**Consultation Response from KC,  
Highways Development Management**

**2020/92546 Land off, Blackmoorfoot Road and Felks Street, Crosland Moor, Huddersfield, HD4 7AD**

**Date Responded:  
16/04/2021**

Z:\projects\1852 Former Fireworks Factory, Huddersfield\CAD\Croft Drawings\1852-F01-F02.dwg

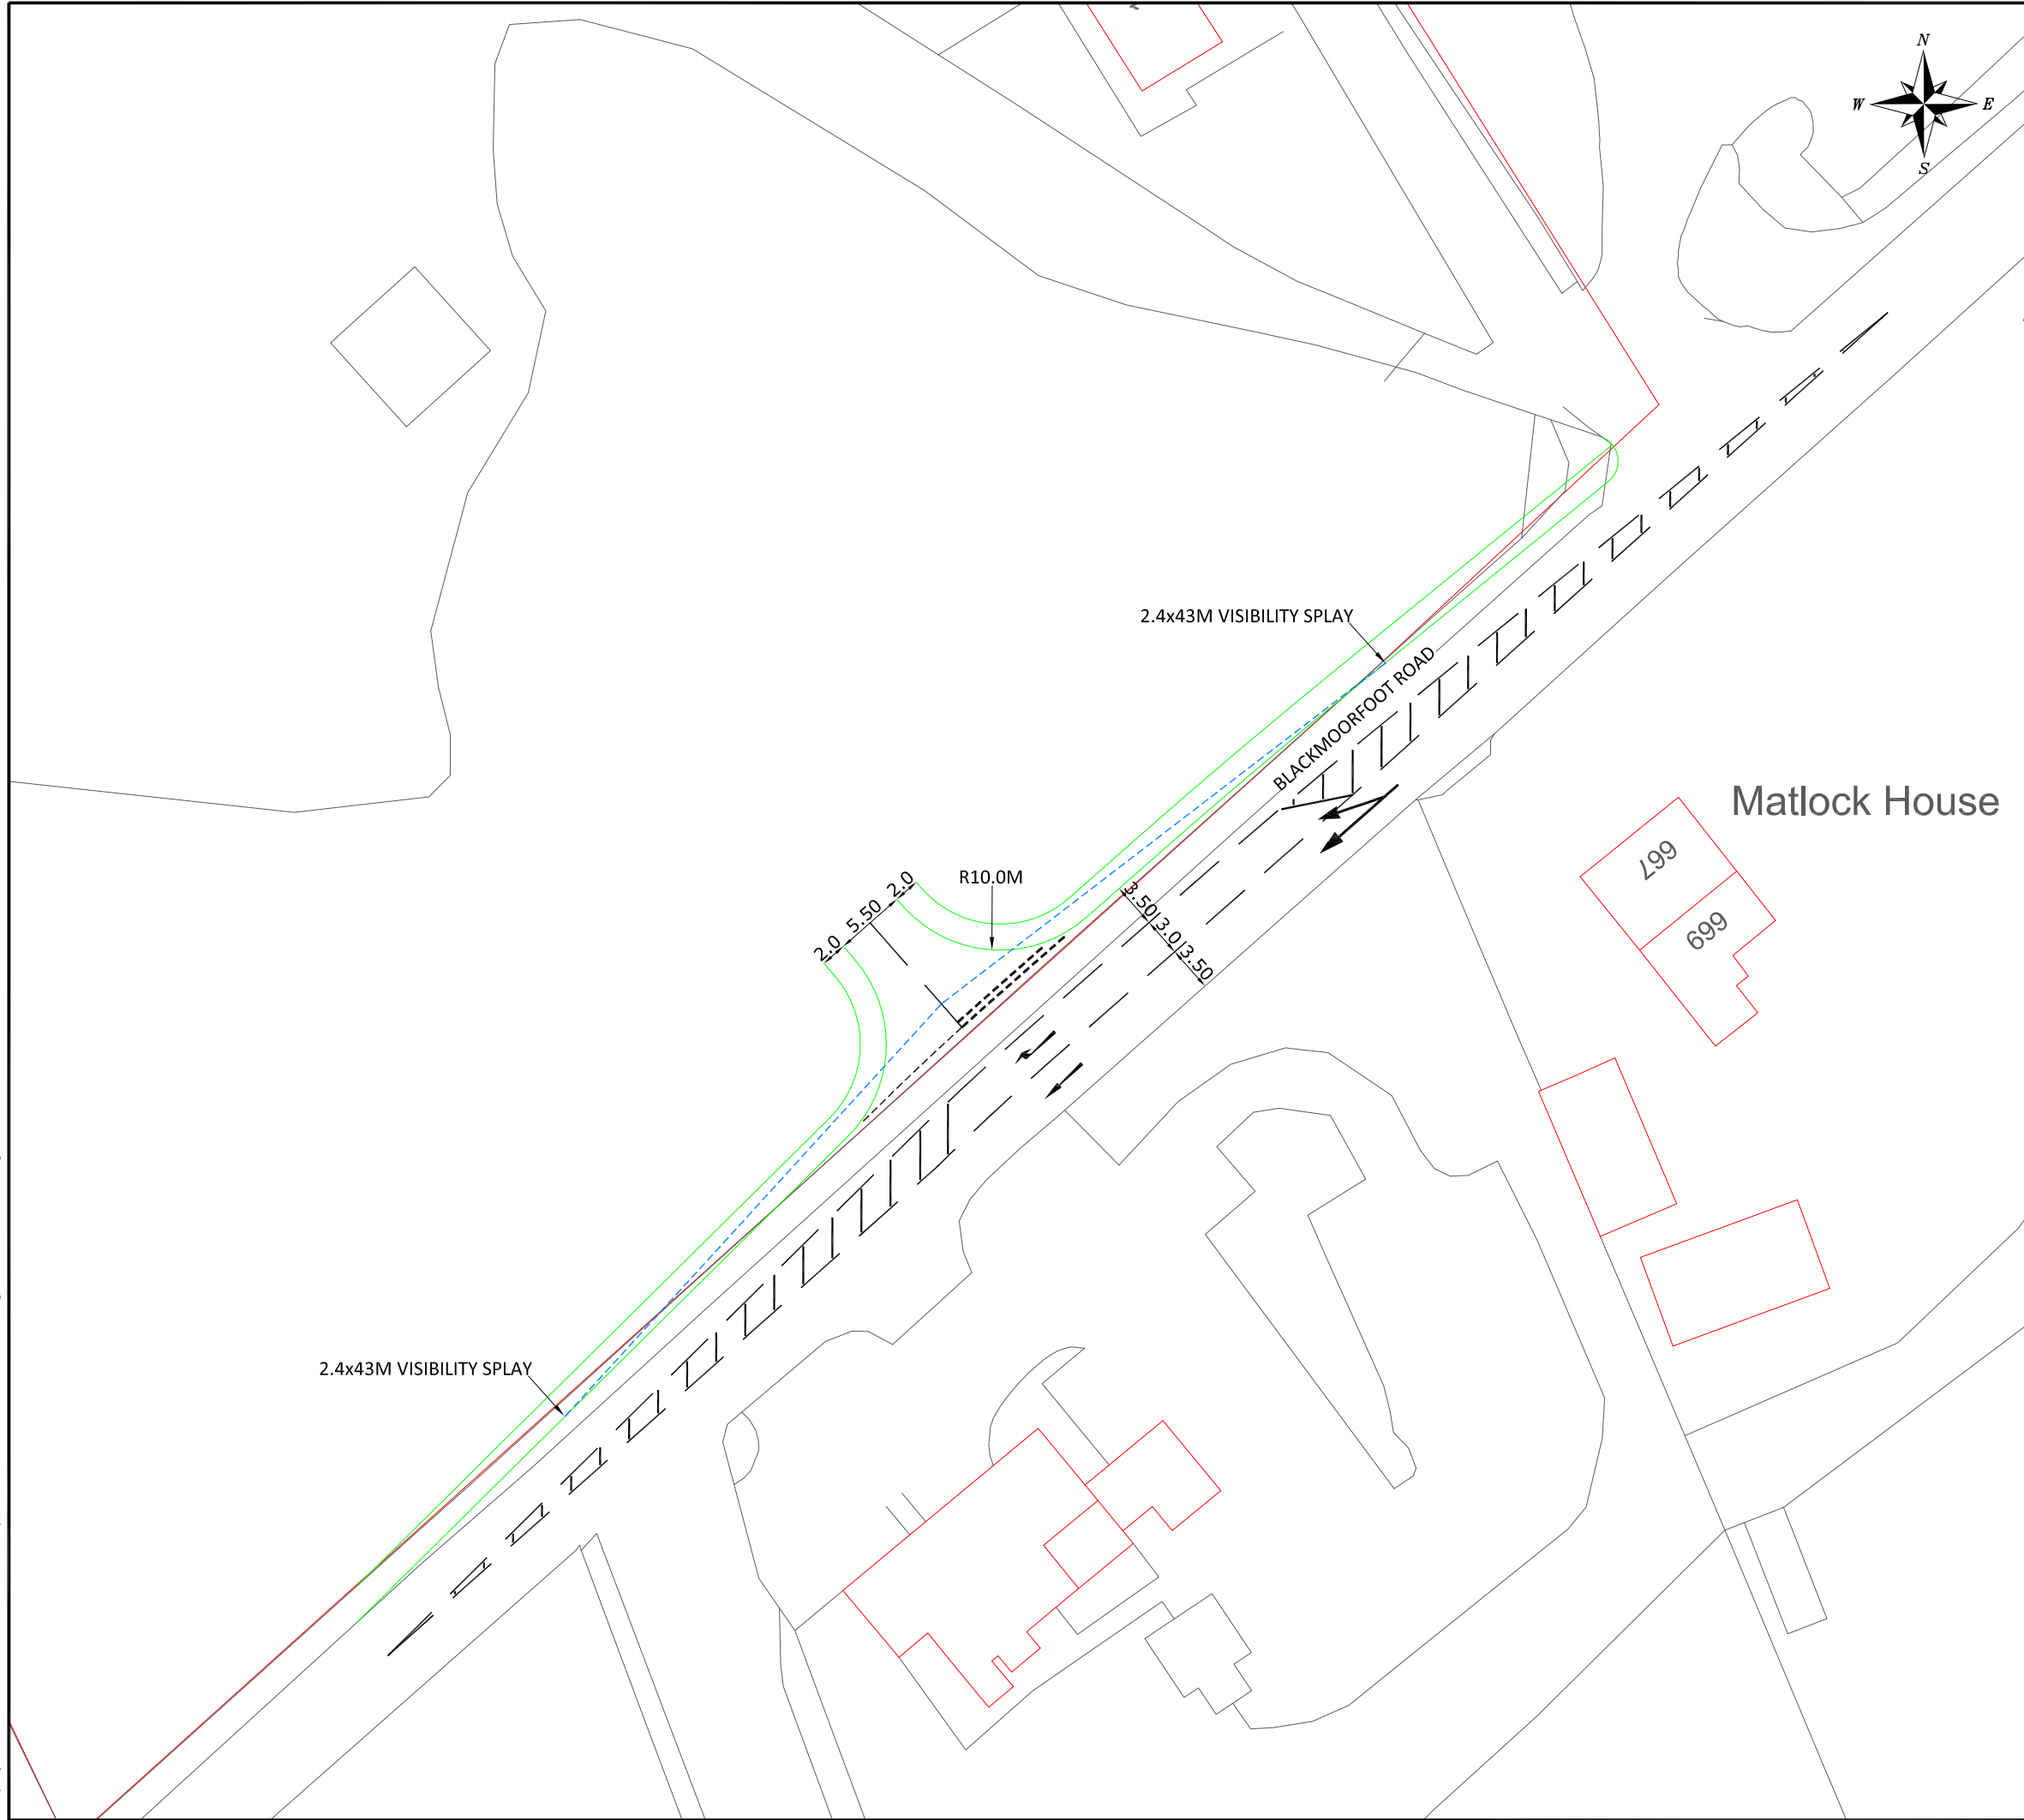
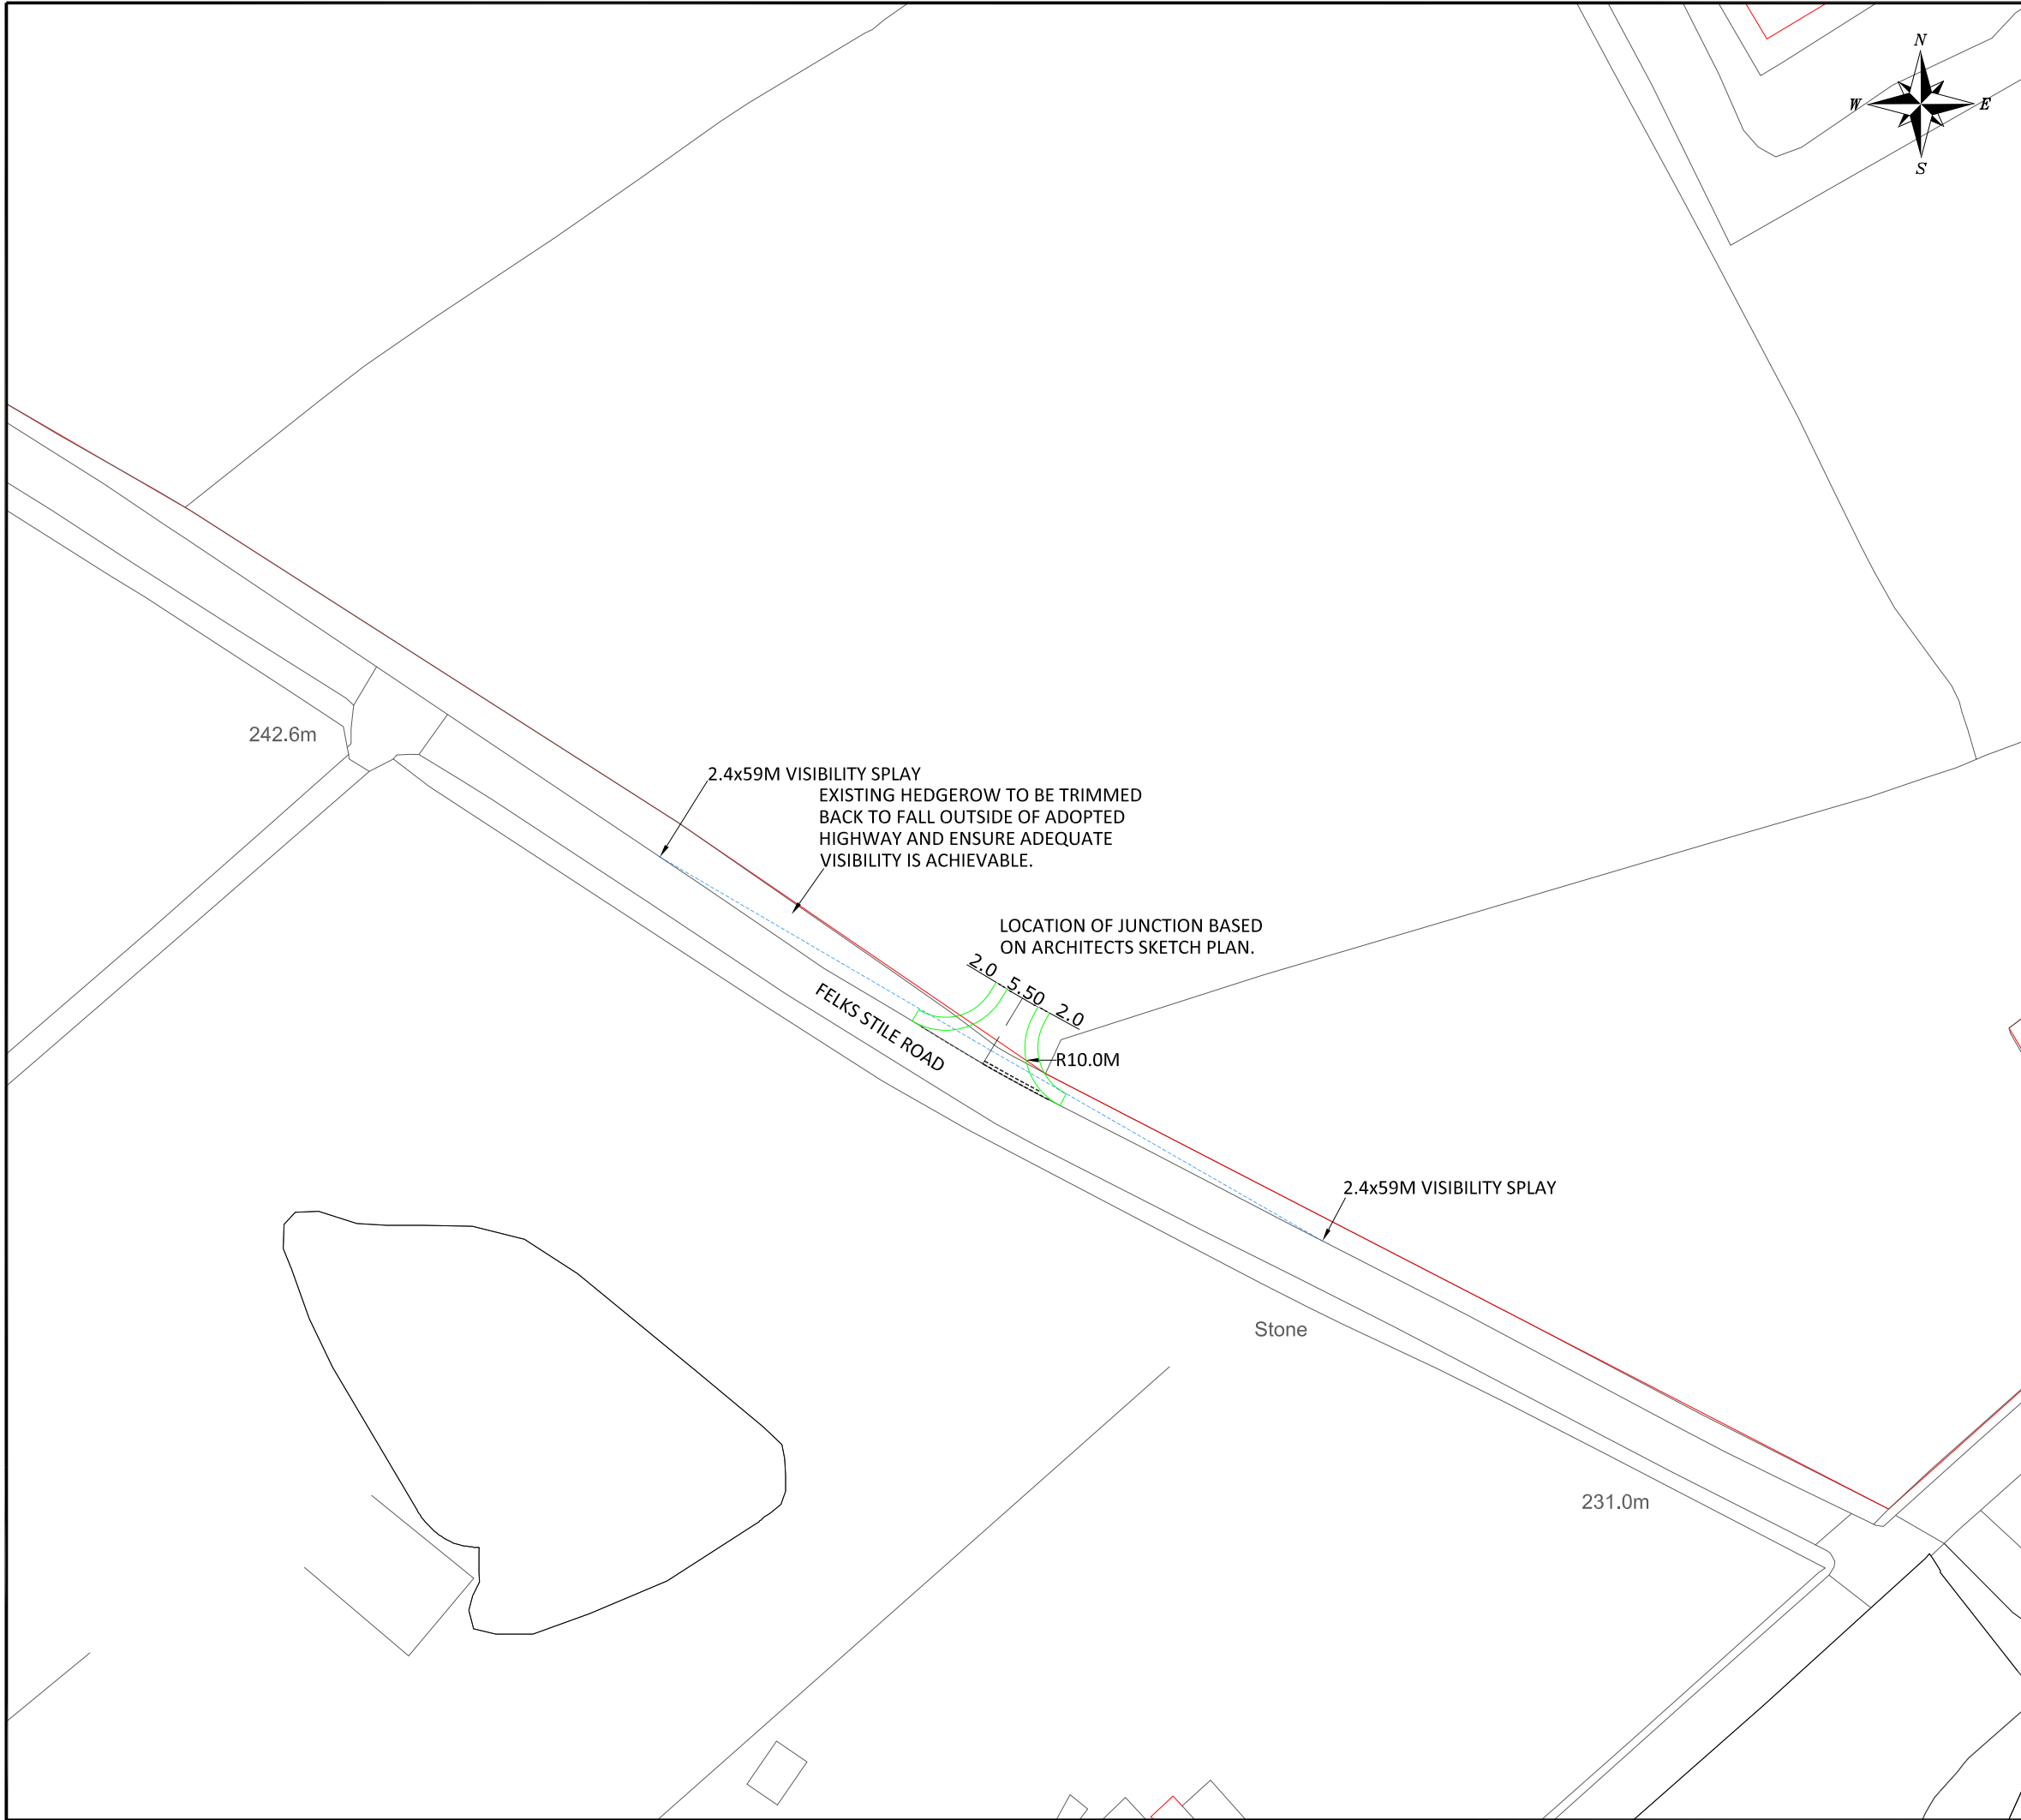
- Contained within the Transport Assessment is a plan which identifies a potential site access of Blackmoorfoot Road (dwg ref 1852-F01). The proposed site access should be of a minimum road width of 6.75m plus cycle lanes to both sides and 2m footways.

Contained within the Transport Assessment is a plan which identifies a potential site access of Blackmoorfoot Road (dwg ref 1852-F01). The proposed site access should be of a minimum road width of 6.75m plus cycle lanes to both sides and 2m footways.

An additional Technical Note (3) has been submitted dated January 2021, this addresses these matters and information on the proposals are attached in the appendices. A framework Travel Plan is also included in this Technical Note.
